WEST SUSSEX COUNTY COUNCIL CONSULTATION

TO:	Arun District Council FAO: J Baeza
FROM:	Highways, WSCC
DATE:	11 April 2018
LOCATION:	Land at Barn Farm, Dappers Lane, Angmering, West Sussex, BN16 4EN
SUBJECT:	A/142/17/PL Change of use of land from storage (B8 Storage or Distribution) to a car sales yard (Sui Generis).
DATE OF SITE VISIT:	
RECOMMENDATION:	☐ Advice ☐ Objection ☐ Modification ☐ No Objection ☒ More Information ☐ Refusal
S106 CONTRIBUTION TOTAL:	£ See below for breakdown.

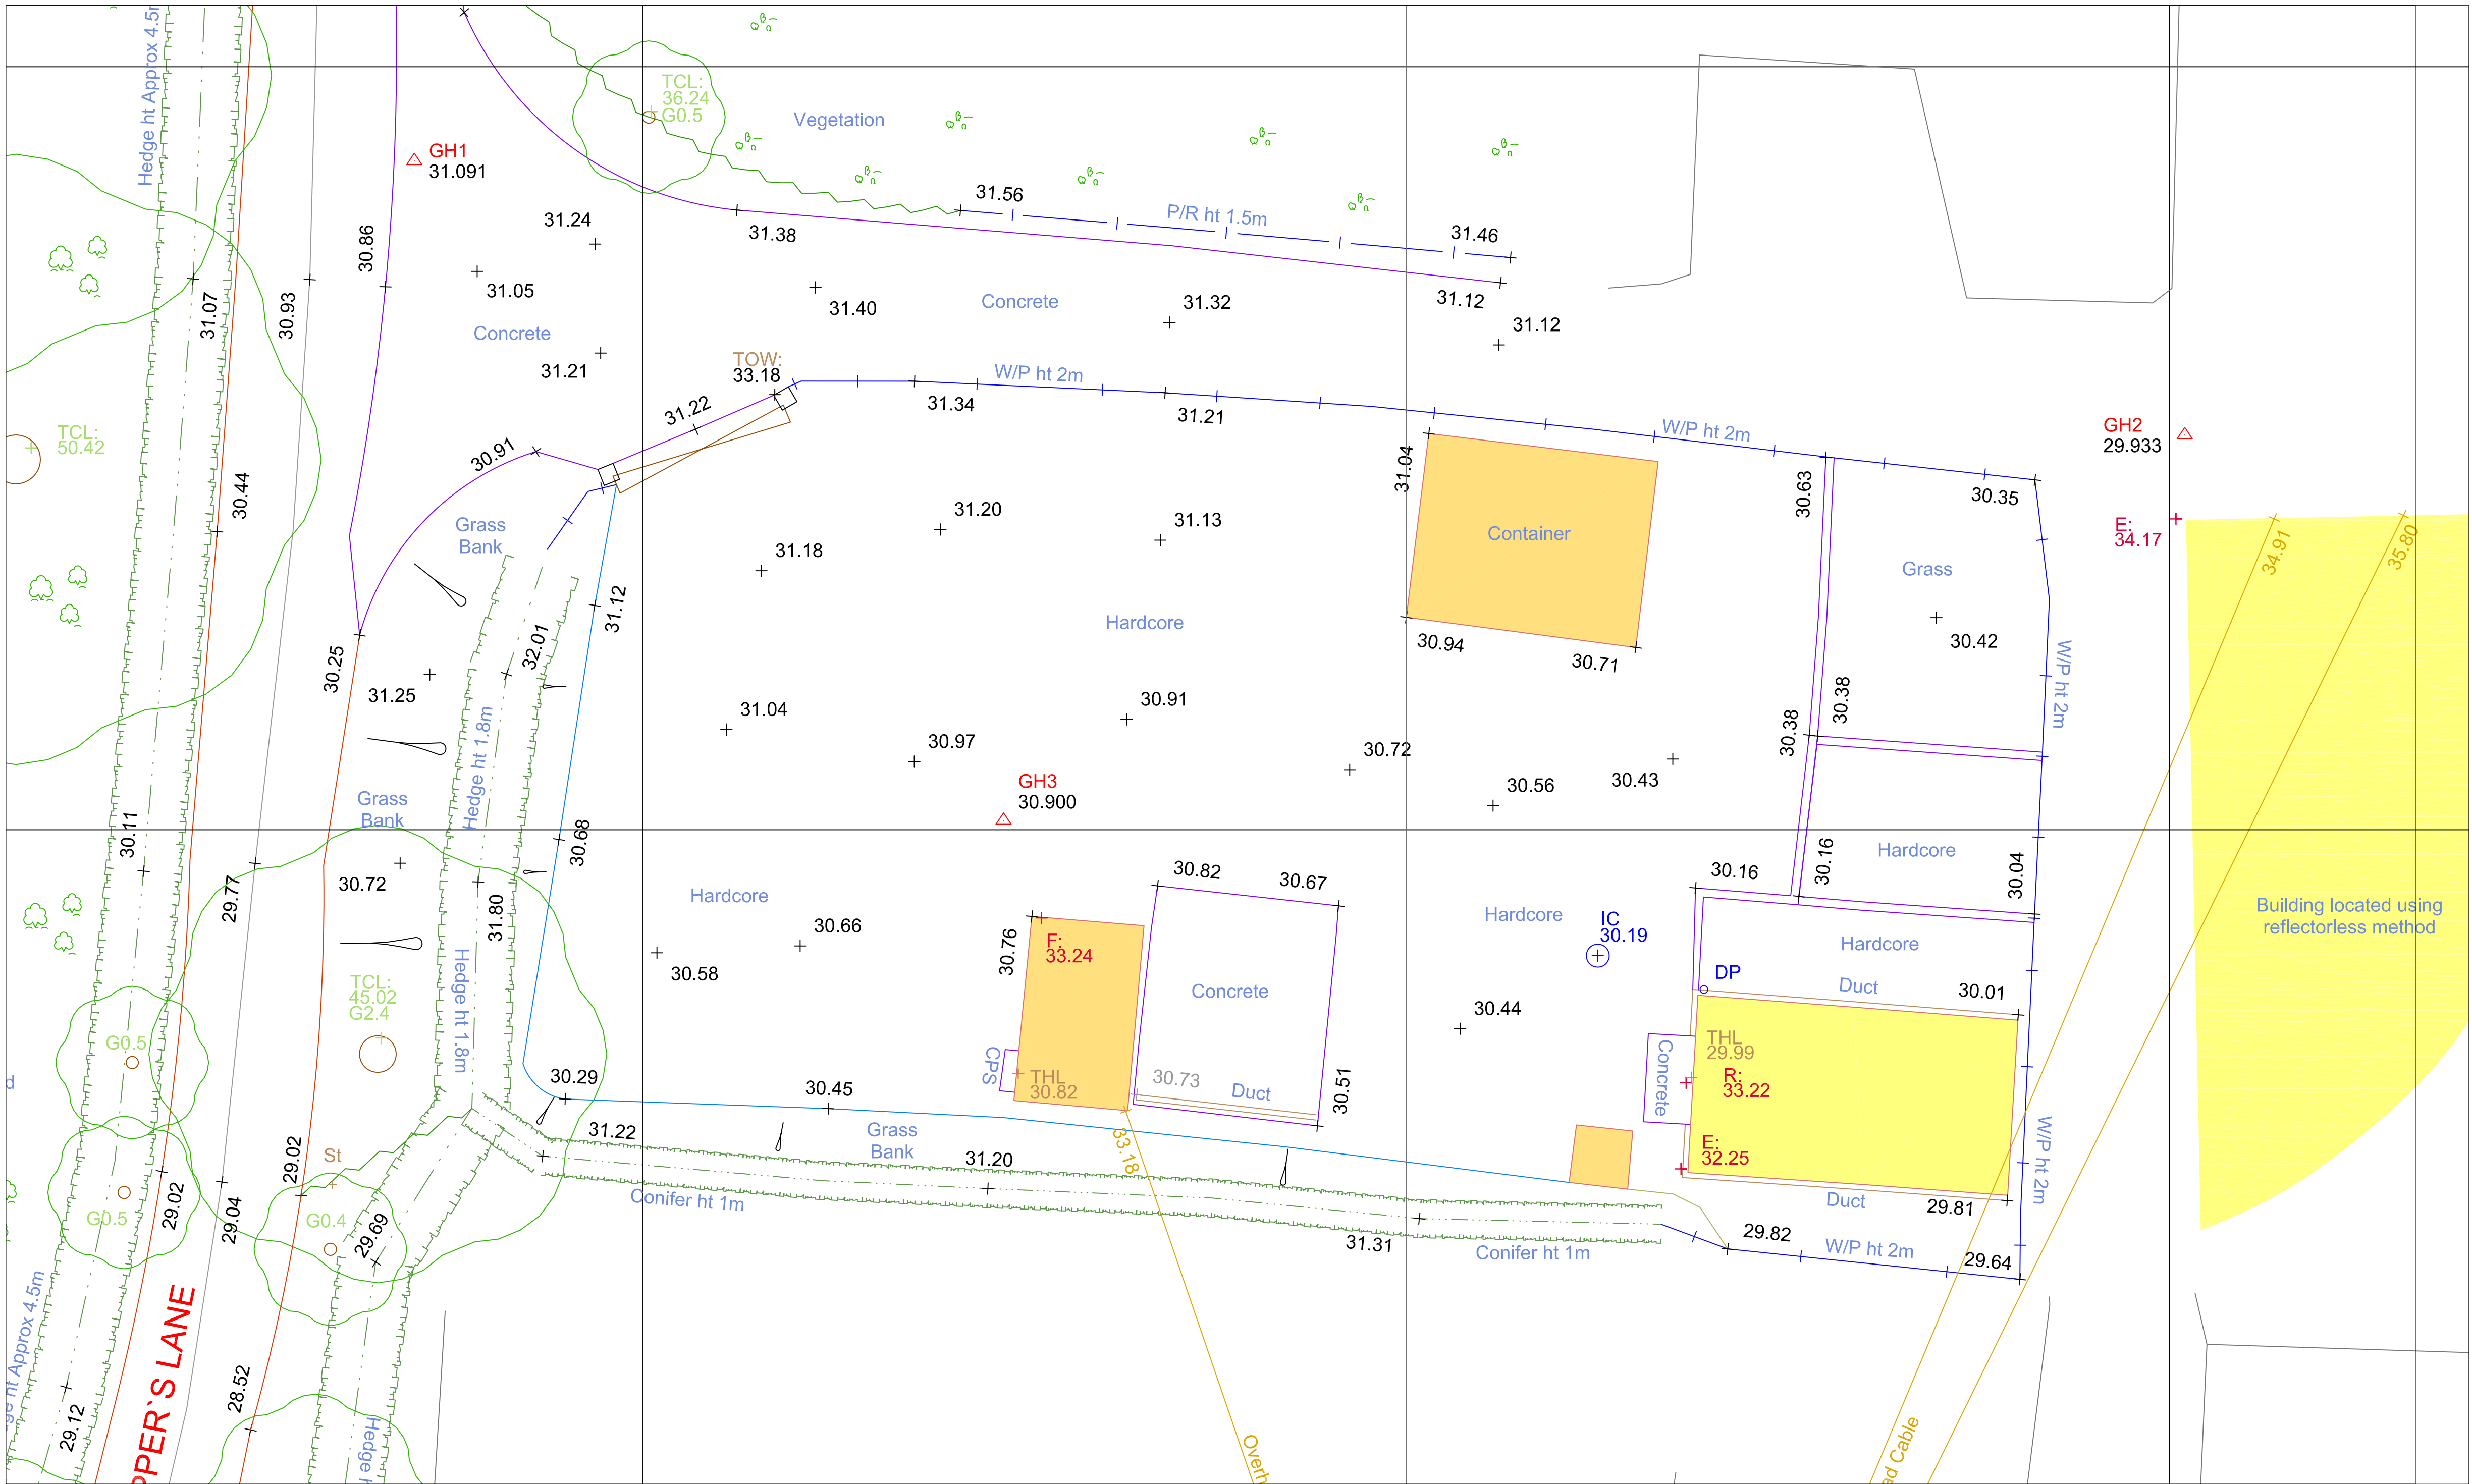
Access – whilst the access geometry appears to be sufficient, the street view from 2012 shows the surface of the access mouth in a poor state of repair.

The site access is within the derestricted section of the lane however it is located just north of the 30/60 termination sign. Therefore, given the rural nature of the road and the slight bend south of the access it is unlikely that speeds will be close to the 60mph speed restriction. It is therefore considered that visibility is acceptable, however splays will need to be maximised and the vegetation within the splays maintained.

There does not appear to be a plan which shows the parking layout, this is required.

In addition, please request the applicant provides additional information with regards to proposed traffic generation ie number of cars on sale, how cars will be delivered (ie on a car transport vehicle), any other operations which will happen on site (ie car maintenance/repair), anticipated number of customers etc. A commitment to the maintenance of the visibility splays and proposed improvements to the access surfacing are also required.

Prior to first commencement of development, visibility splays at the site access shall be maximised in accordance with a plan to be submitted and approved by the Local Planning Authority by the cutting back of vegetation adjacent to the site access. Once provided the splays shall thereafter be maintained and kept free of all obstructions over the height of 0.6m above adjoining carriageway level or otherwise agreed.
